**Consultation Response from KC,
Highways Development Management**

2024/90859 Land at, Ash Street, Birkby, Huddersfield, HD1 6HN

**Outline application for the demolition of buildings and the erection of light industrial units
(Class E (g) (iii))**

Date Responded: 28-5-2024.

Site Plan - As Proposed

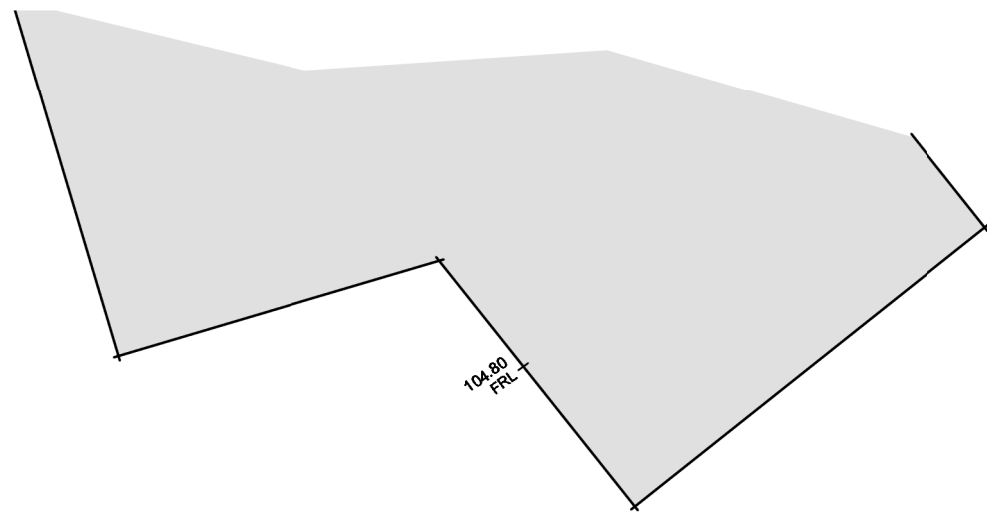
No detailed design has been prepared; however, a proposed indicative layout has been submitted to show the potential siting of the individual units, parking facilities, turning spaces and landscaping.

The proposals utilise the existing access onto Miln Road.

Ash Street meets Miln Road at an acute angle which will make the left in and right-out turning movements difficult particularly for a larger vehicle. Larger HGVs will not be able to turn left in or right-out out of the site. Sight lines from Ash Street onto Miln Road are poor in both directions and there are no pedestrian facilities along Ash Street between Miln Road and the proposed site.

The indicative layout shows 3 small units with 10 off-street parking spaces and further space for internal vehicle turning which could potentially be acceptable subject to the applicants providing acceptable vehicle swept paths.

The access via Ash Street however is severely sub-standard in terms of its width, alignment with Miln Road which will make turning movement difficult and potentially impossible for larger vehicles, sight lines on to Miln Road and the lack of pedestrian facilities.

Highways Development Management have therefore little alternative other than to recommend refusal of these proposals on highway safety grounds.
